28 January 2016

Your ref: SSD 7264

**TQ Holdings Australia Pty Ltd Port Kembla Bulk Liquids Terminal (SSD7264)
State Significant Development Application Submission**

Figure 1.1: Individual fatality risk contours

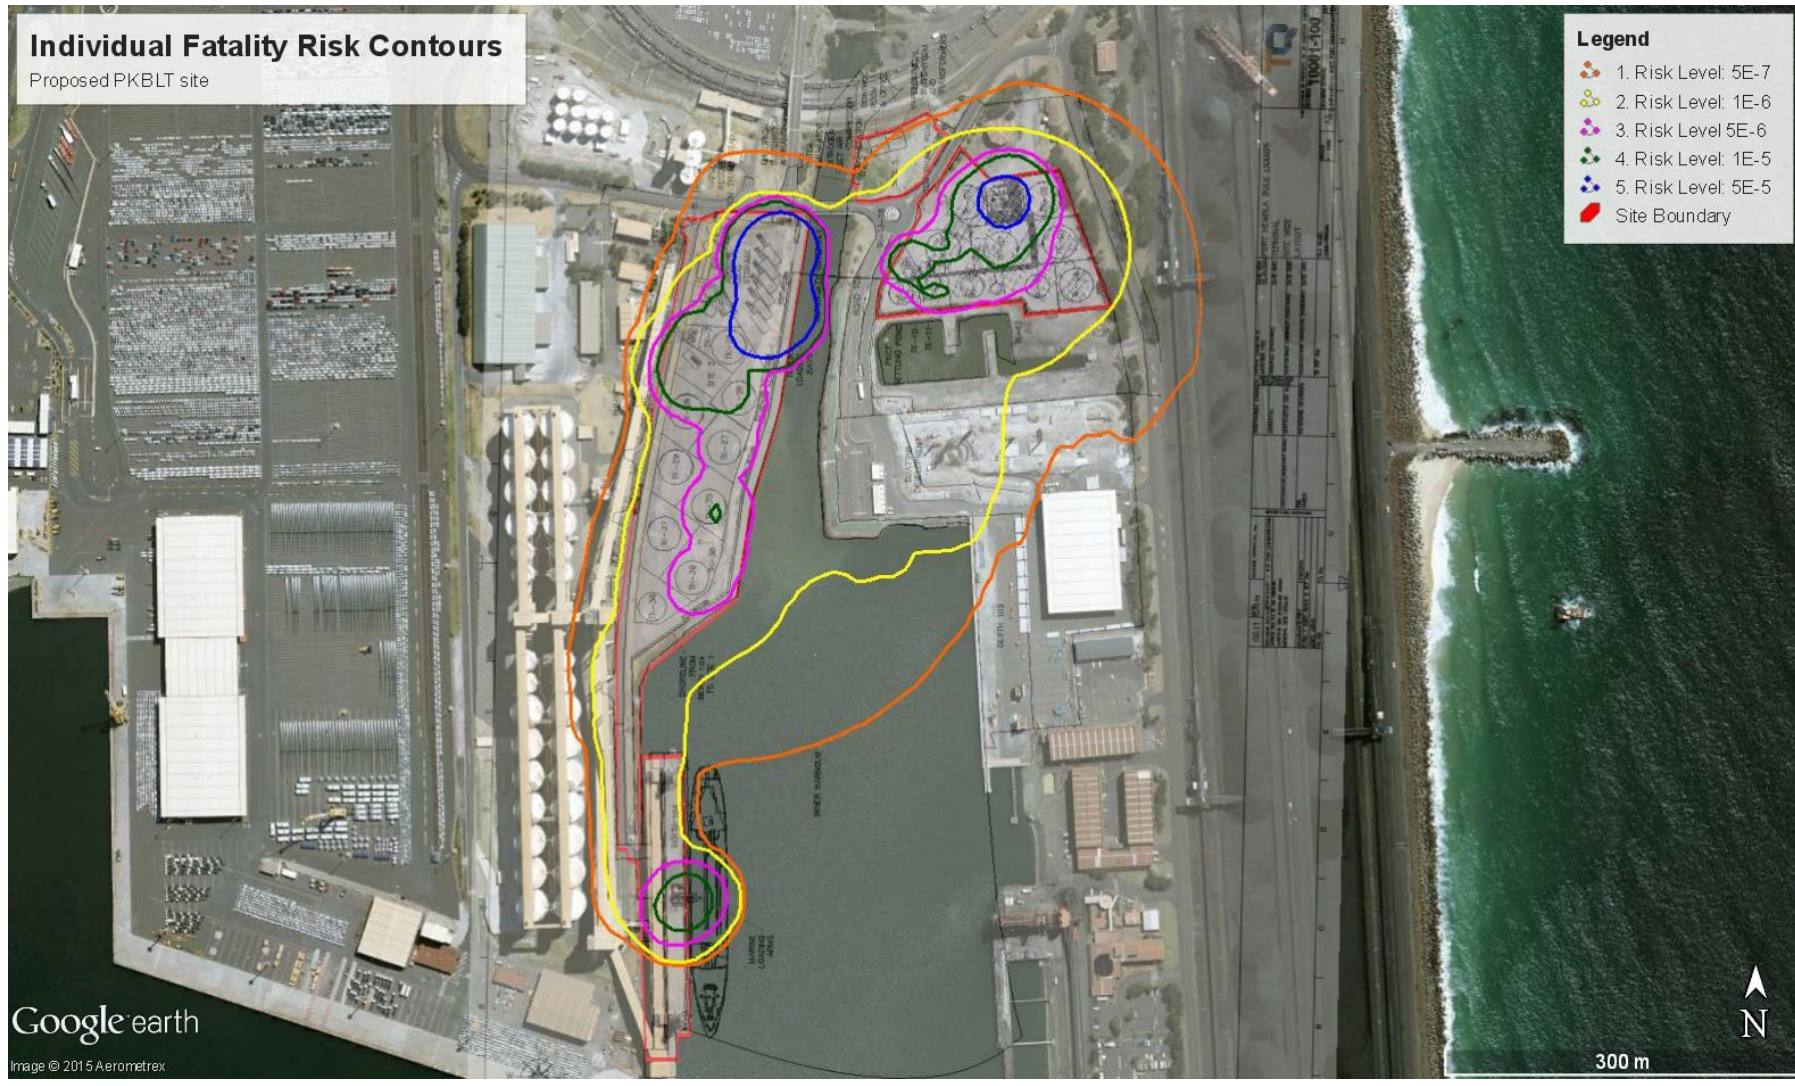
Class 3 tank and/or bund locations may necessitate GrainCorp plant isolations and /or asset modification (e.g. intrinsically safe electrics conversion and constraint on vehicles on road to berth). A professional peer review of the development PHA recommends that more information is required to make a better informed assessment of potential impacts, namely:

- 1) Provide plot plan overlays of thermal radiation impact zones at 12.6kW/m² and 23kW/m² for fire incidents from tank top and bund fires related to loss of containment events for flammable and combustible liquids. Show the location of assumed fire centres and the associated pool diameters of the major fires.
- 2) Provide plot plan overlays of isopleths for major flammable liquid evaporation and dispersion events for F2 conditions. Show both LFL and ½ LFL isopleths.
- 3) Provide justification for the use of TNO failure frequency data (5×10^{-6} per year) for “major” losses from large storage tanks, compared with the UK HSE value of 100×10^{-6} per year as seen in reference 17 of the PHA.

This will help understand the possible implications of key incidents and some assumptions on nearby GrainCorp plant and operations.

Figure 3.3: Proposed site layout

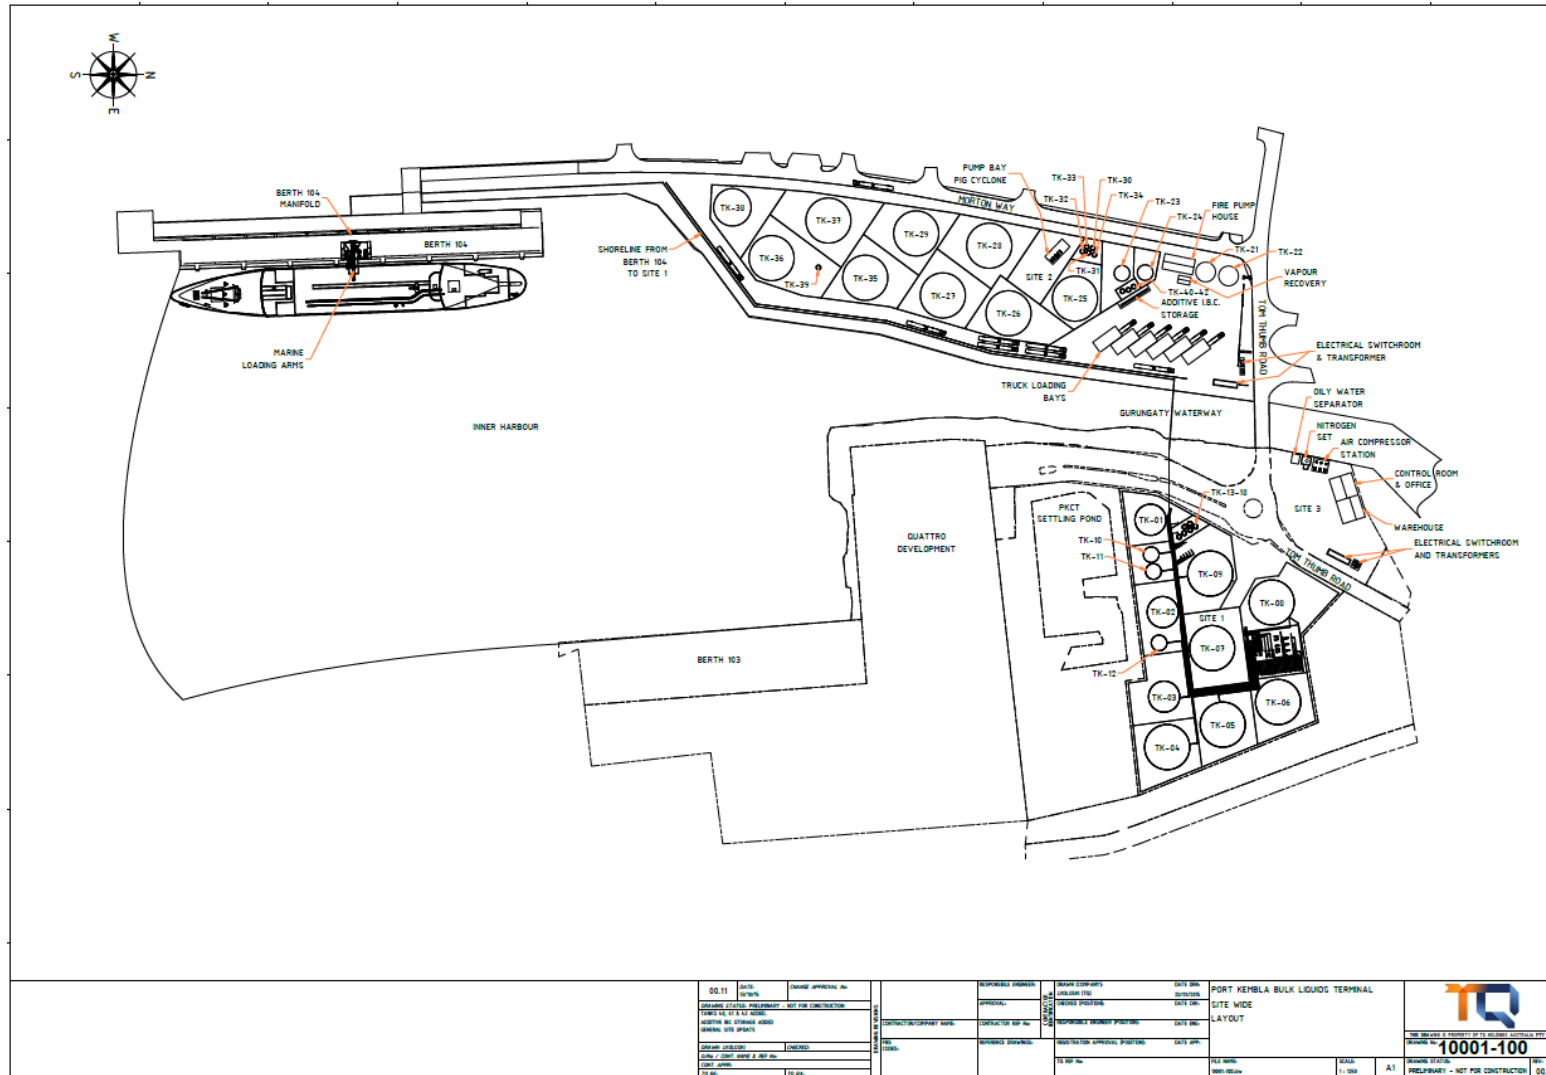
Site 3 includes a sediment pit currently used by GrainCorp as an exit point for licenced stormwater discharges. The impact of the proposal to this area and alternative discharge areas is not explained within the DA submission and as such GrainCorp is unable to adequately assess the potential impact to our operations.

GrainCorp’s lease boundary extends north of the Berth 104 Access Bridge, overlapping with one of the TQ lots.
